Ask for: Sharon Horner
Telephone: 01832 742001
Planning Services
Our Ref: NE/21/01765/FUL
Your Ref: PP-10448426
Date: 8 December 2021

**Proposal: Orangerie extension at East Wing Clopton Hall Main Street
Clopton Kettering Northamptonshire NN14 3DZ.**

drawing no.	CO.EW.PO1	A
drawn	checked	
scale	As shown @ A2	date
		November 2021

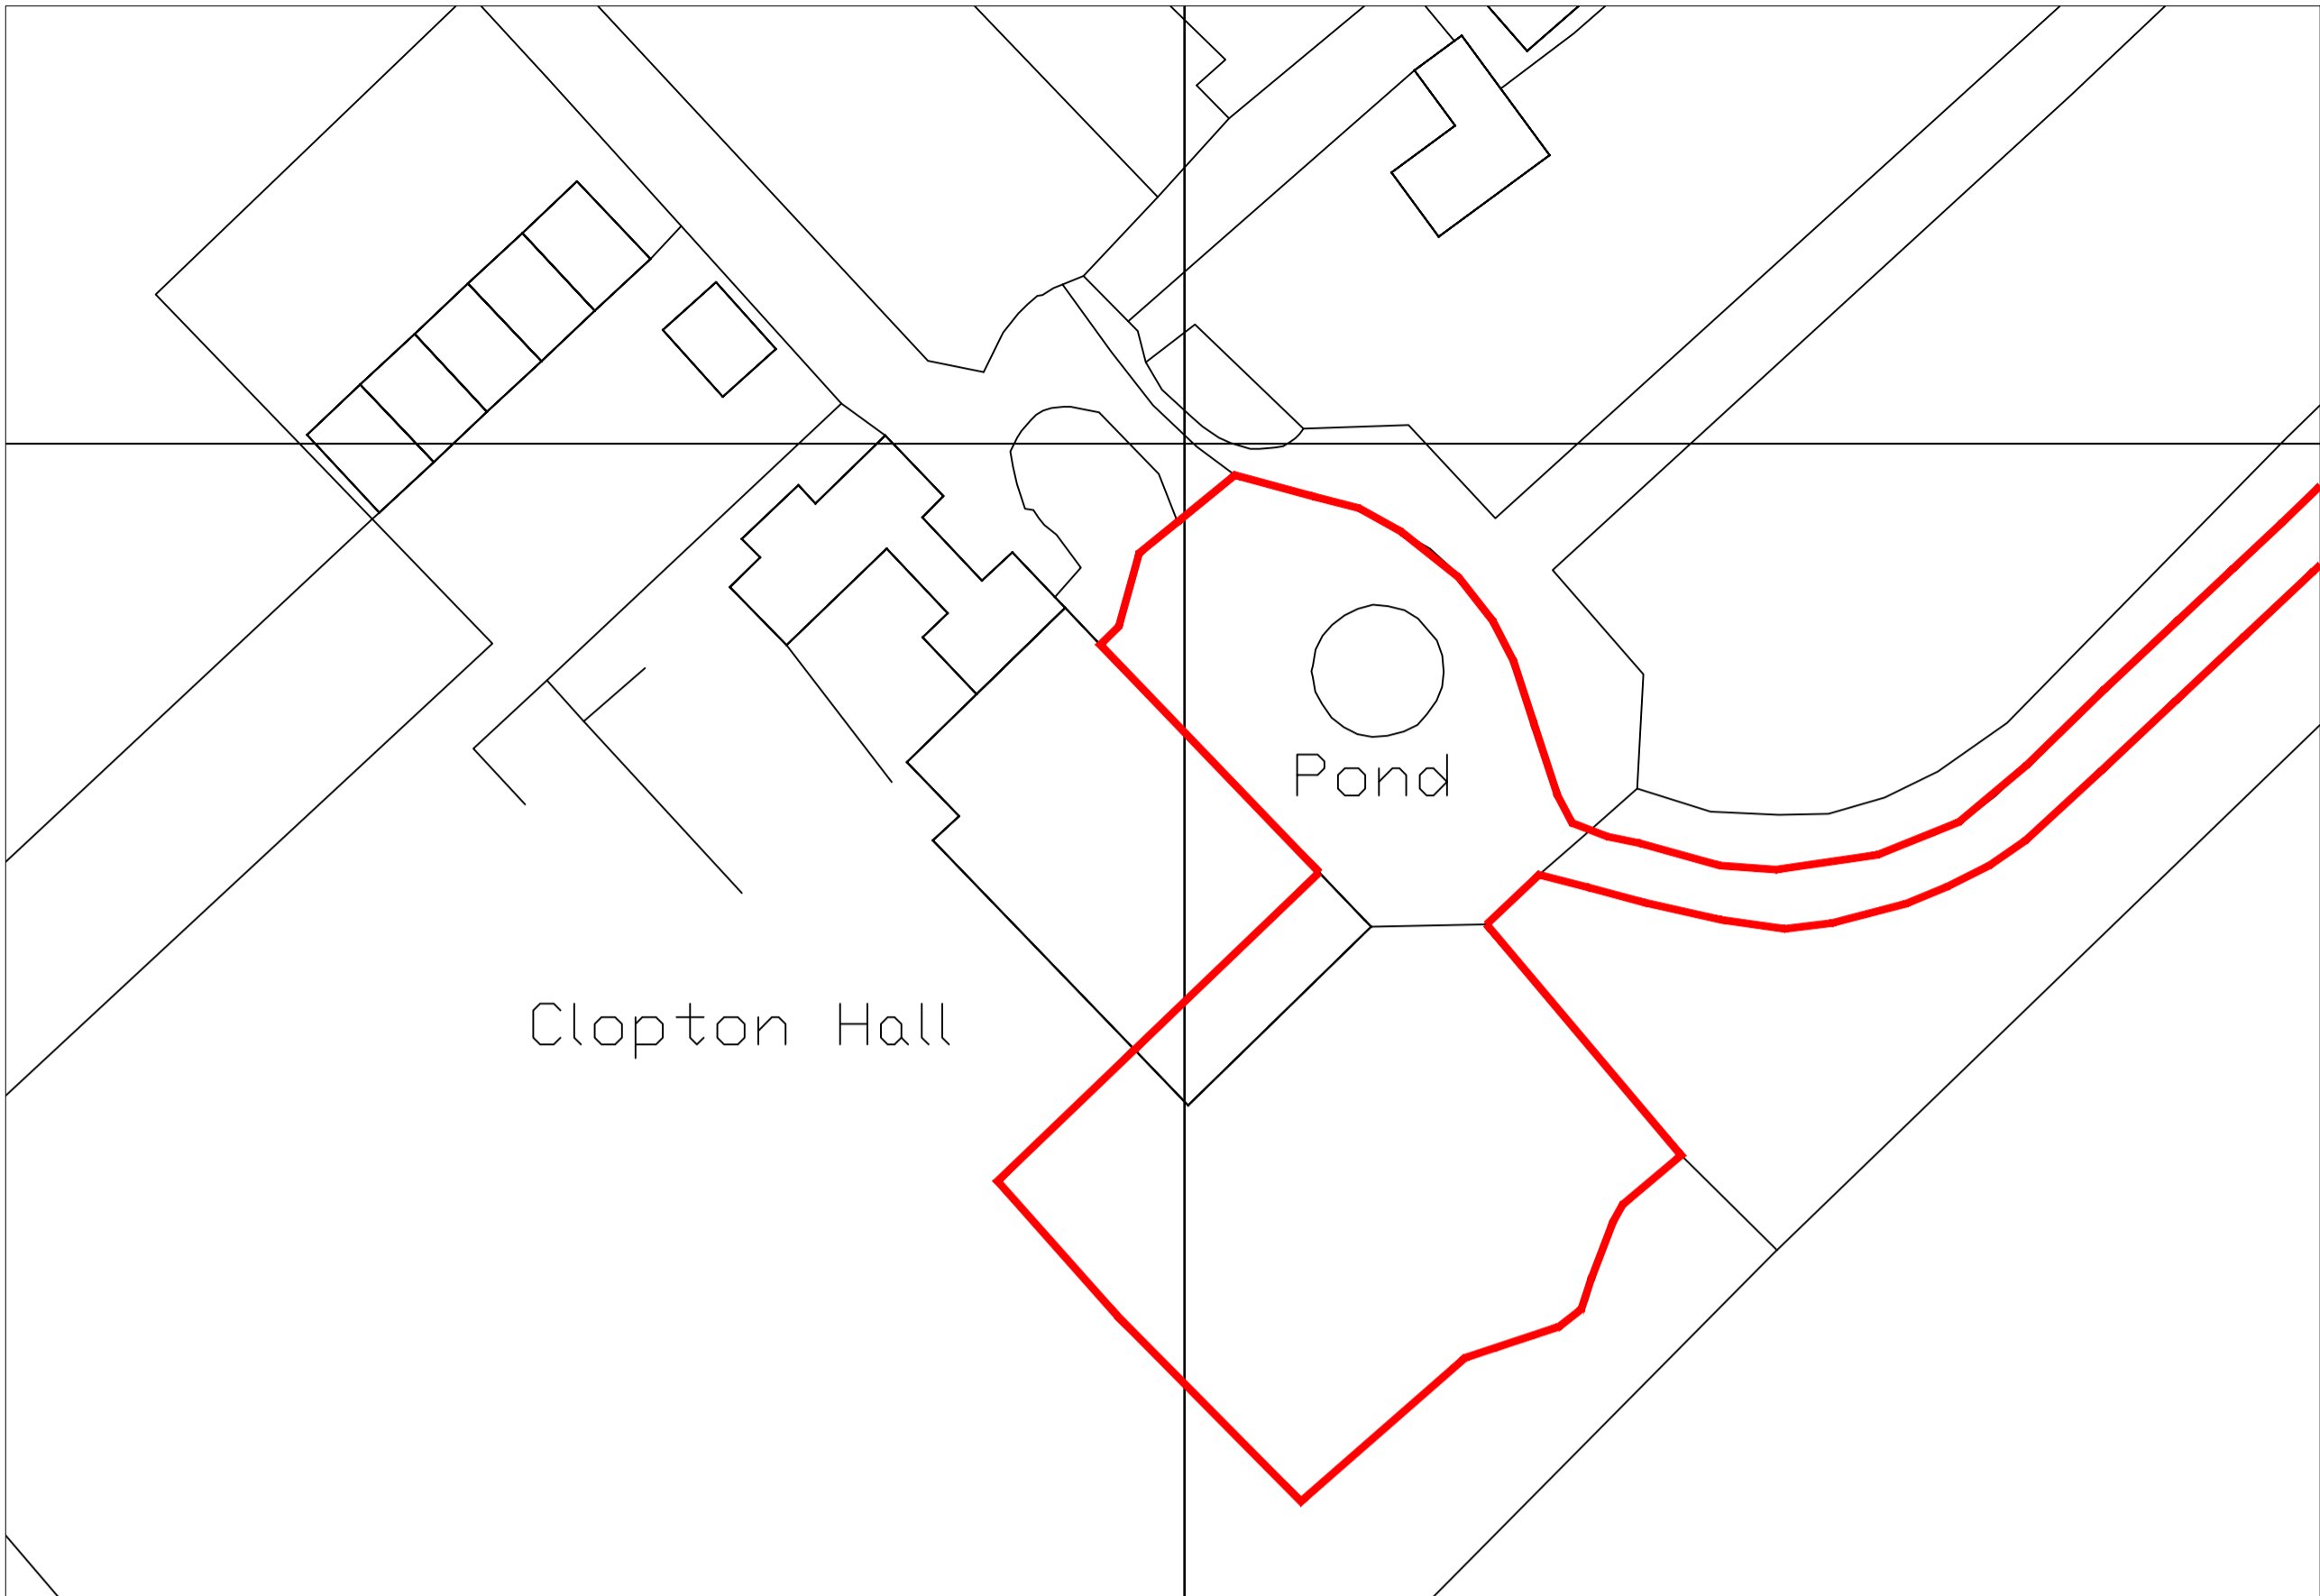
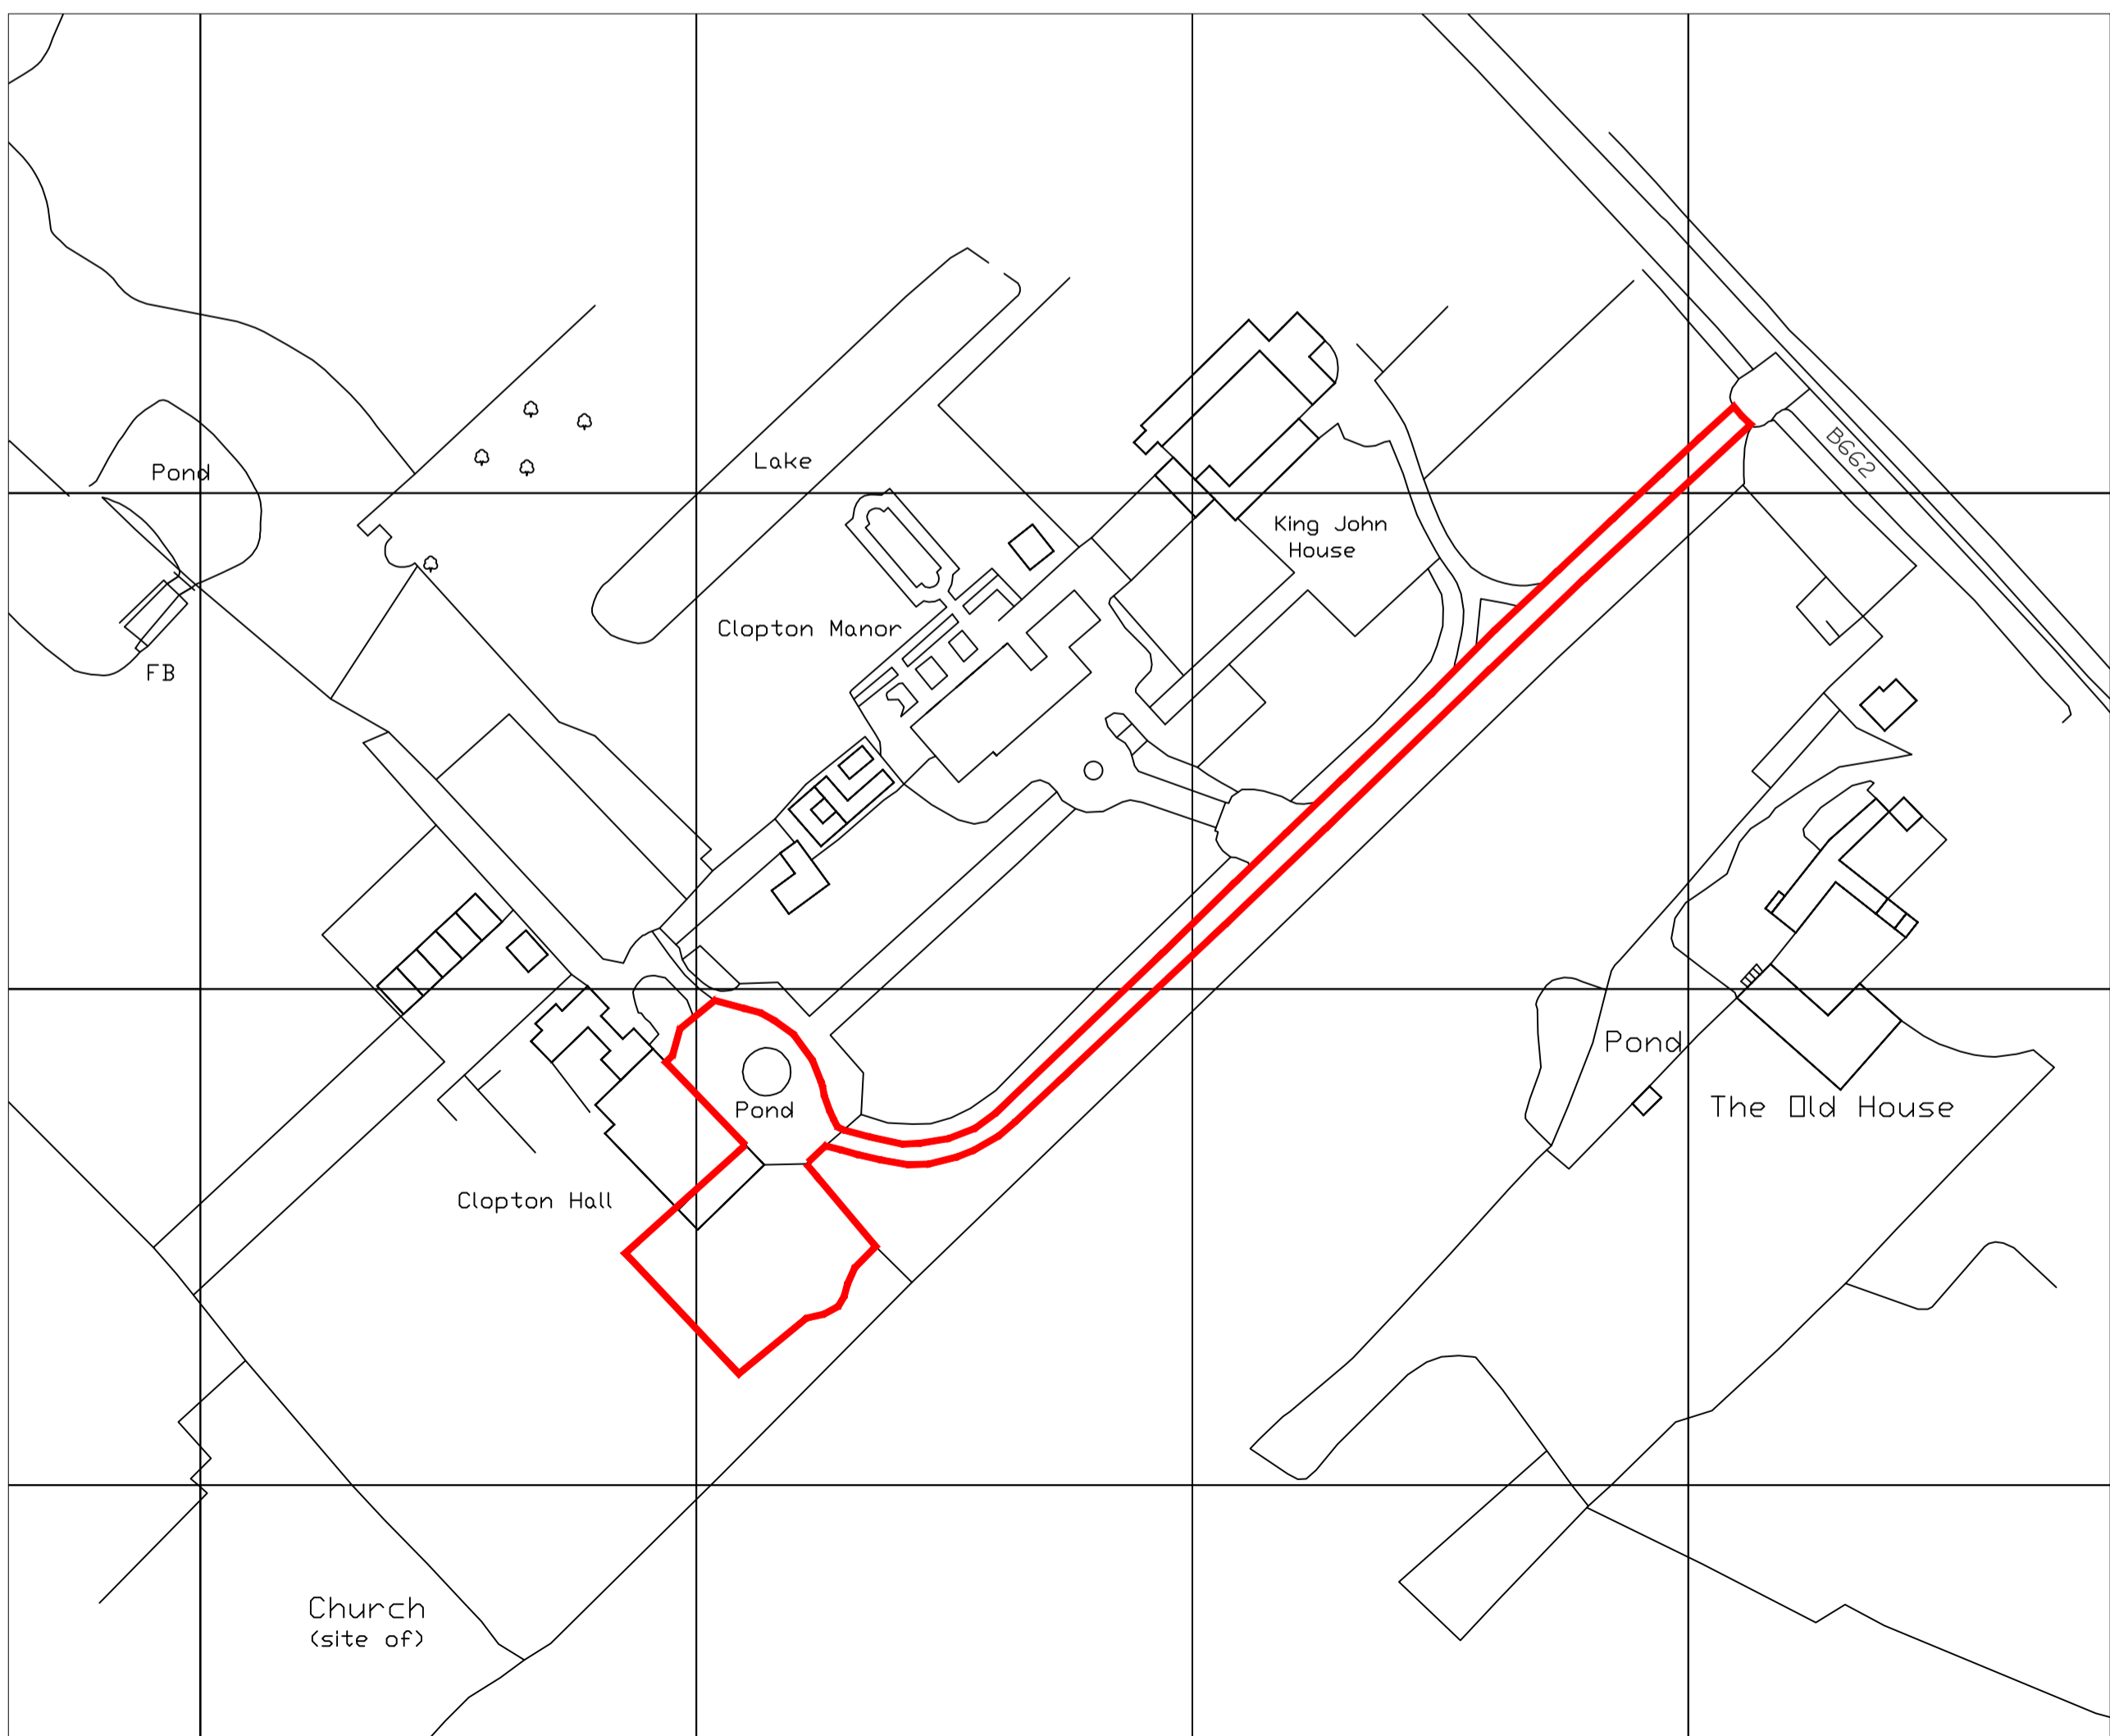
2. The submitted 'location plan', does not include the access within the red outline. Unfortunately, we are not able to accept this plan, as per National requirements, http://www.east-northamptonshire.gov.uk/downloads/file/9124/local_list_of_information_requirements a continuous red line should be around the entirety of the site, up to and including the access to the highway. Please provide an amended location plan accordingly.
3. All applications involving operational development on sites that contain trees, or where they are present on an adjacent site, will be required to be accompanied by the arboricultural reports/plans detailed below:
 - Tree Survey
 - Finalised tree retention/removal plan
 - Tree protection plan
 - Retained trees and root protection areas shown on proposed layout plan
 - Arboricultural Impact assessment
